Arun District Council
Arun Civic Centre
Maltravers Road
Littlehampton
West Sussex BN17 5LF
Planning & Building Control General
Enquiries
Tel: (01903) 737756 Fax: (01903) 730442
Dx: 57406 Littlehampton
Minicom: 01903 732765
e-mail: planning@arun.gov.uk
website: www.arun.gov.uk/planning
Our Ref: FP/233/11/
Your Ref:

11th January 2012

**Front ground floor extension
28 Alfriston Close Felpham**

DRAWING
PROPOSED ELEVATIONS
DATE: NOVEMBER 2011
DRAWN: T. Murray
DRAWING: 11/35/4

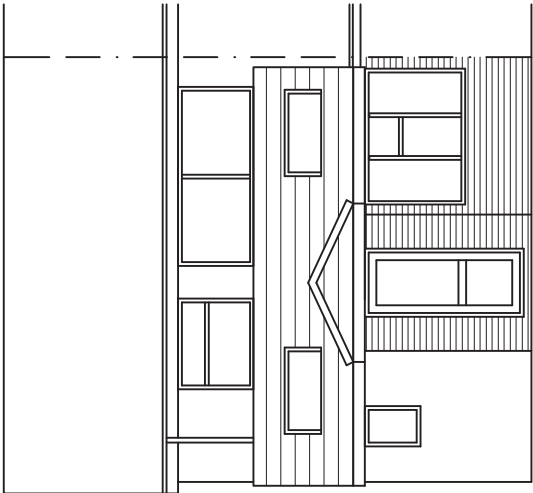
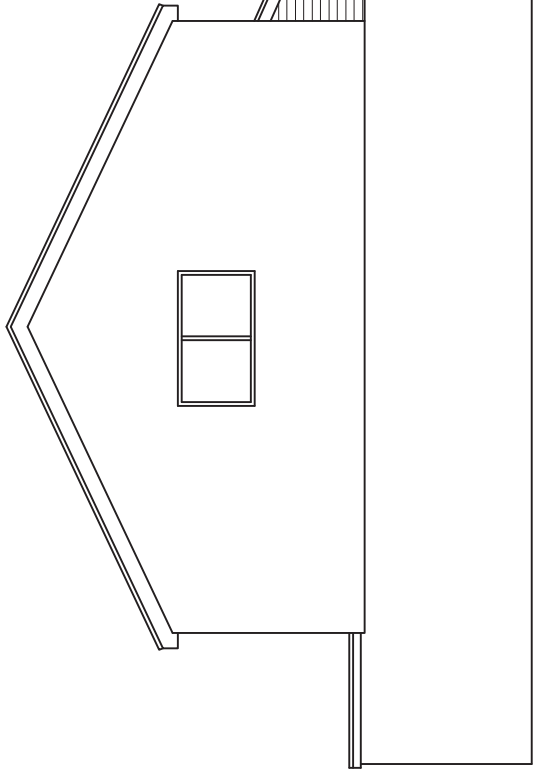
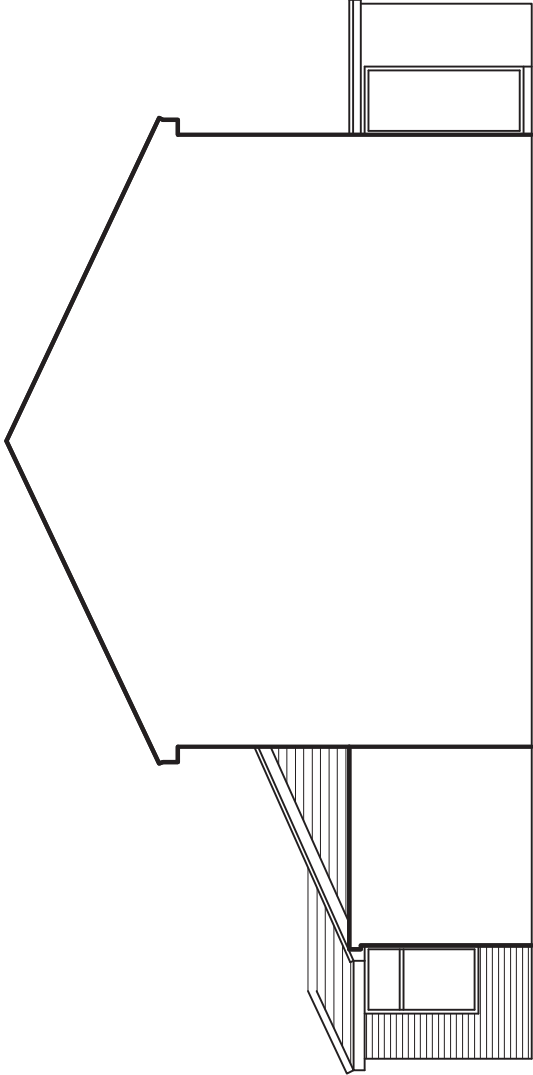
✓ Please provide 1 electronic or 3 paper copies of revised proposed elevations of the proposed front extension as there is still either a window or a door missing from the side elevations in accordance with the guidance notes available on our website detailed below (click on National List).

28AlfristonClose

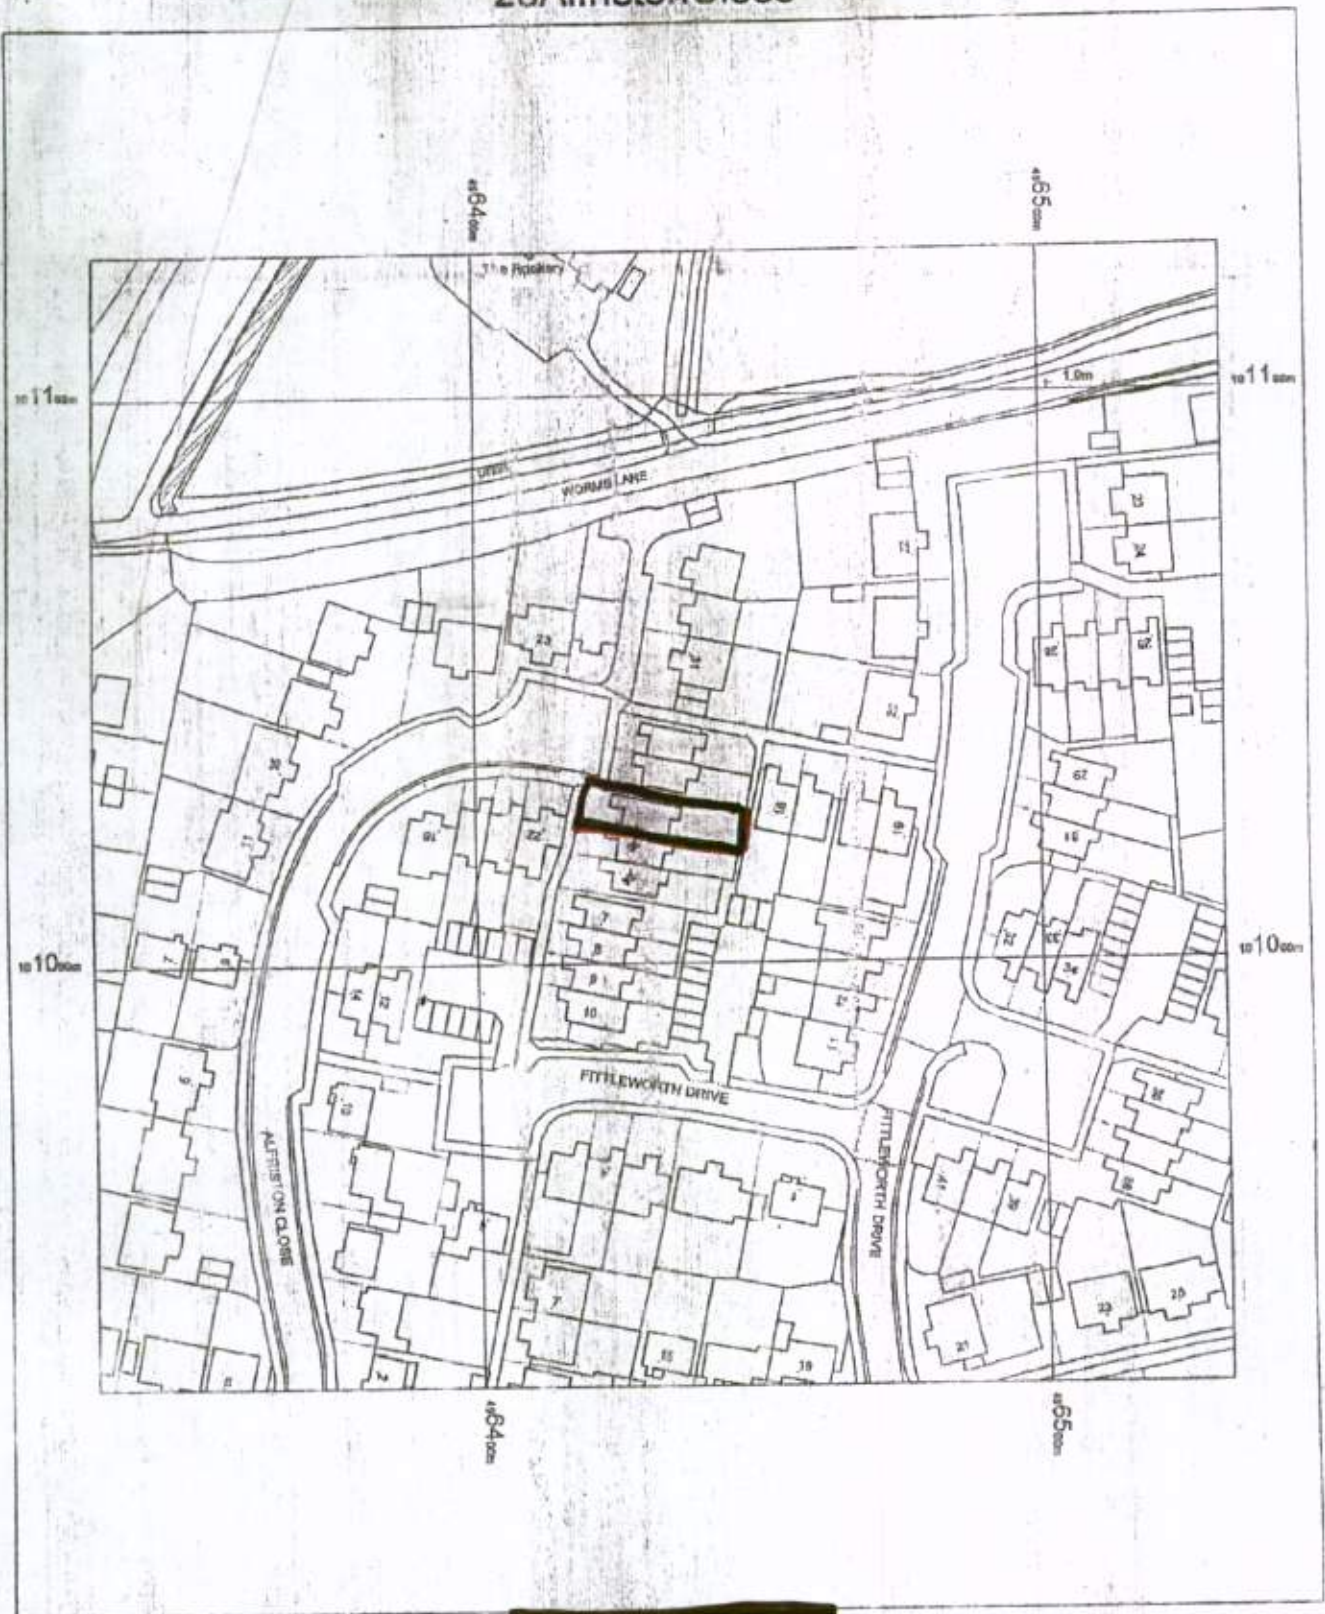
I require 1 electronic or 3 paper copies of a revised location plan with an amended scale bar, in accordance with the guidance notes available on our website detailed below (click on National List). The revised Block plan you have now provided now scales against the Location plan, however the scale bar on the location plan is now incorrect. Please could you either send in revised location plans omitting the scale bar or give me permission in writing to block out the scale bar, if this would be more convenient.

✓ Please see email dated 25/01/12.
